Table 5: 2021-2024 Audit Findings and Proponent Response

Site Plan

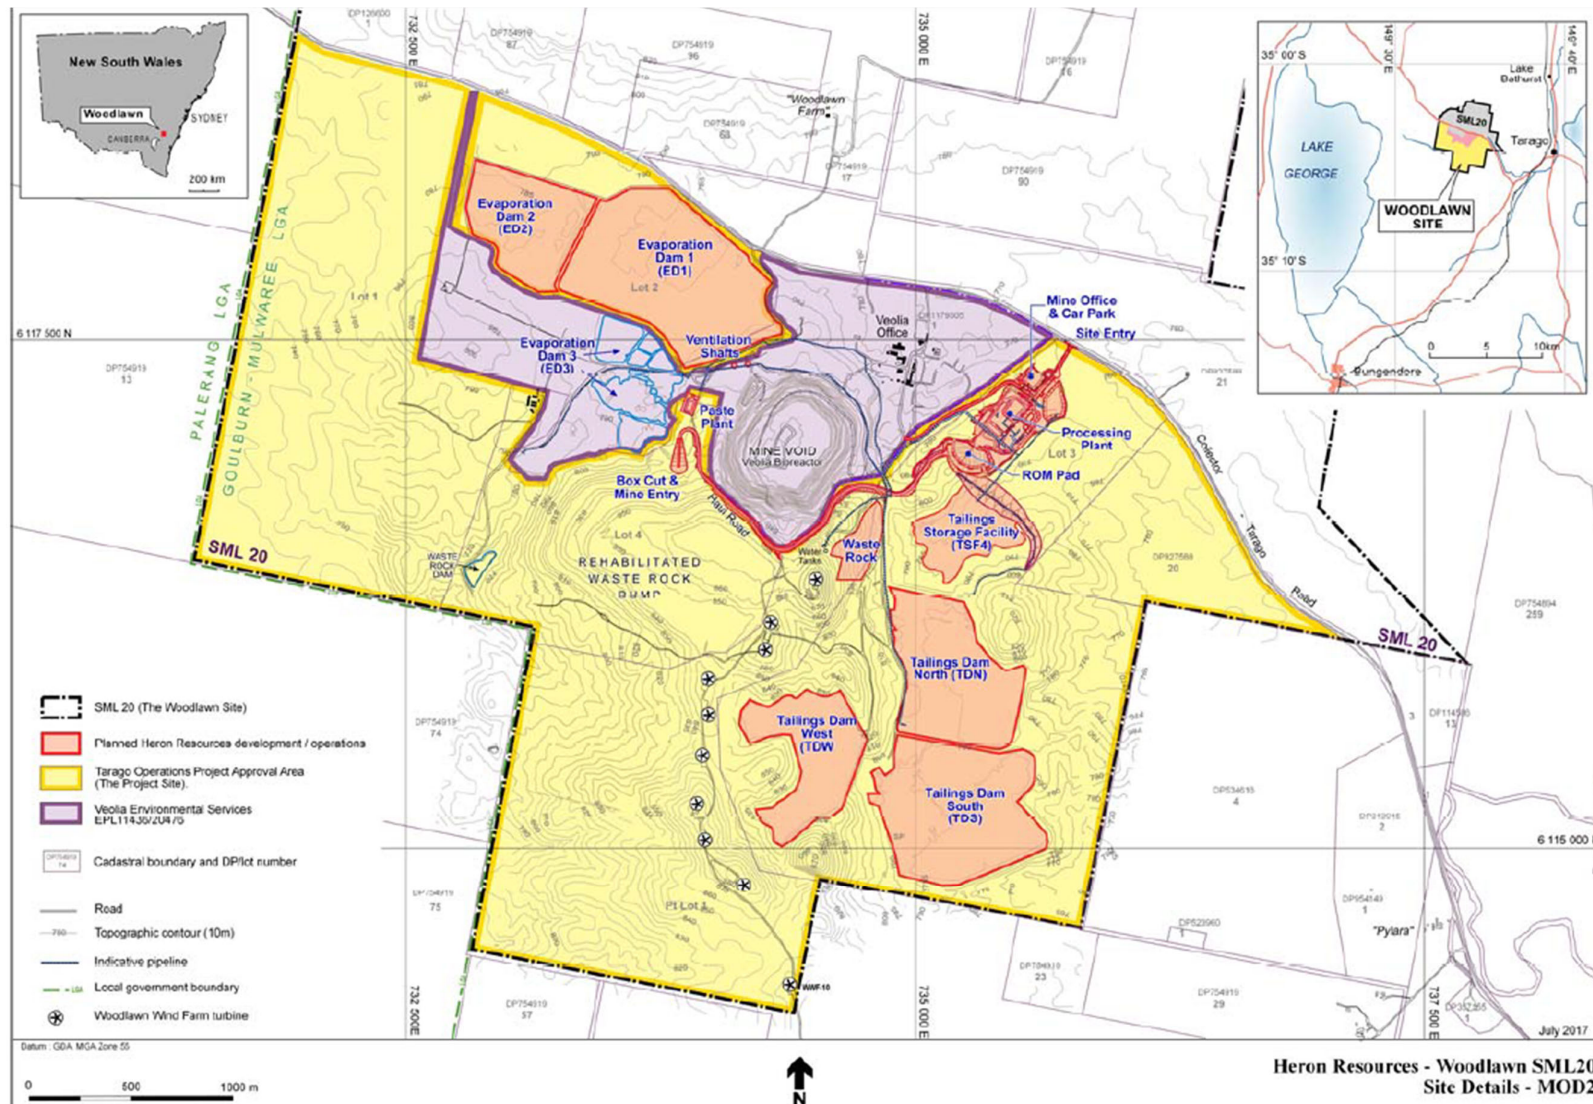
SML20 3. Mining Operations Plan and Rehabilitation Report	The location of the waste rock dump was moved from the approved location. The approved location was an existing vegetated area and rather than remove the vegetation, the dump was moved to an already cleared location a short distance away. Heron notified the DPIE of the breach and the non-compliance was reported in the NSW Resources Regulator Compliance Audit (Feb 2020). The location of the box cut mine entry was also altered and was the subject of a penalty notice. Heron advised that the new locations will be included in the PA MOD3 application.	Non-Compliant	NC3	Agree. This will be included in a subsequent modification.	Prior to the resumption of extractive mining operations
PA 07_0143-MOD2					
Schedule 3 Condition 1 Tailings Dams, Performance Measures	Seepage from TDS has been managed through lining of the seepage return dam and drainage upgrade works, in lieu of seepage source identification. Recommendation: This condition requires review in PA MOD3 to remove reference to tailings reprocessing and note the alternative management strategy, as approved by the Regulator.	Compliant		Agree. This will be included in a subsequent modification.
